Application No: M/123/21/PL
Site Address: 27 Central Drive Middleton-On-Sea PO22 7TT
Description of works: Erection of 1 No. 2 bed detached dwelling. This application is in CIL Zone 4 and is CIL liable as new dwelling.

Thank you for your internet representation made on 17th October 2021 which has been recorded as an objection with the comments as follows:

OWPC41268

Site Plan

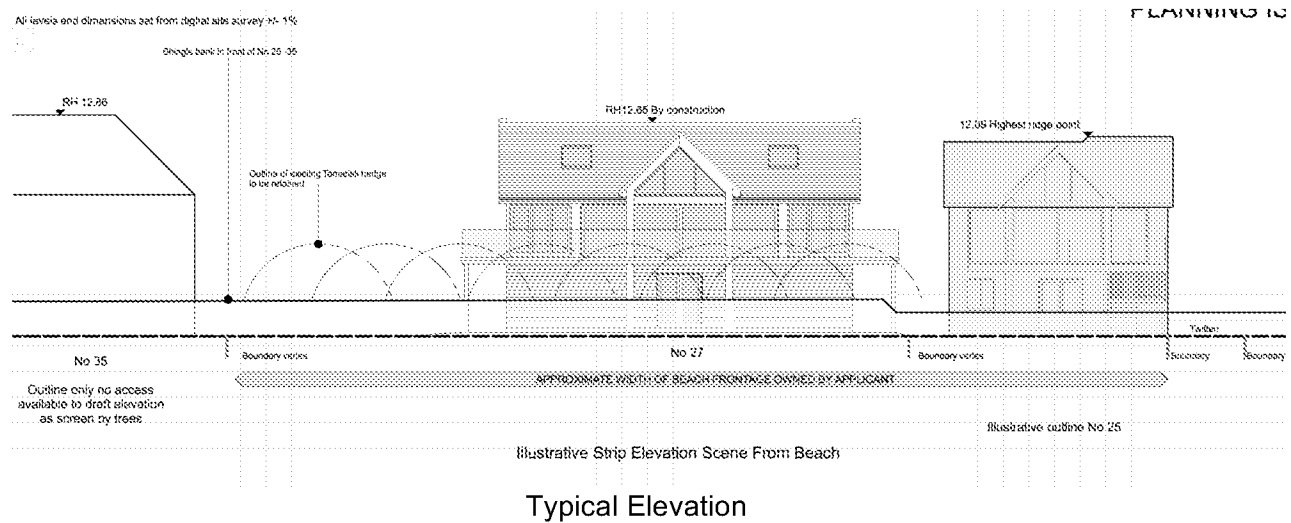
The elevation drawings indicate that the height of this proposed new house, no 27, will still be 0.55 metres higher than the next door dwelling, no 25, despite previously stating that the height of the new house would be in line with immediately surrounding properties.

This site is between our house and the beach. We have access to the beach via a path which runs immediately to the west of this site. We appreciate that the height of this new property is proposed to be lower than the immediate property on the other side, no 35. However, you will see from the site plan that both 25 and 27 are much closer to the beach than no 35 and thus dominate the view from the beach. They are overbearing to beach users in a way that no 35 is not.

We cannot see any logical reason why Arun District Council would allow this property to exceed the roof height of the immediately nextdoor property with the same proximity to the beach (no 25) and we are therefore writing to formally object to this application.
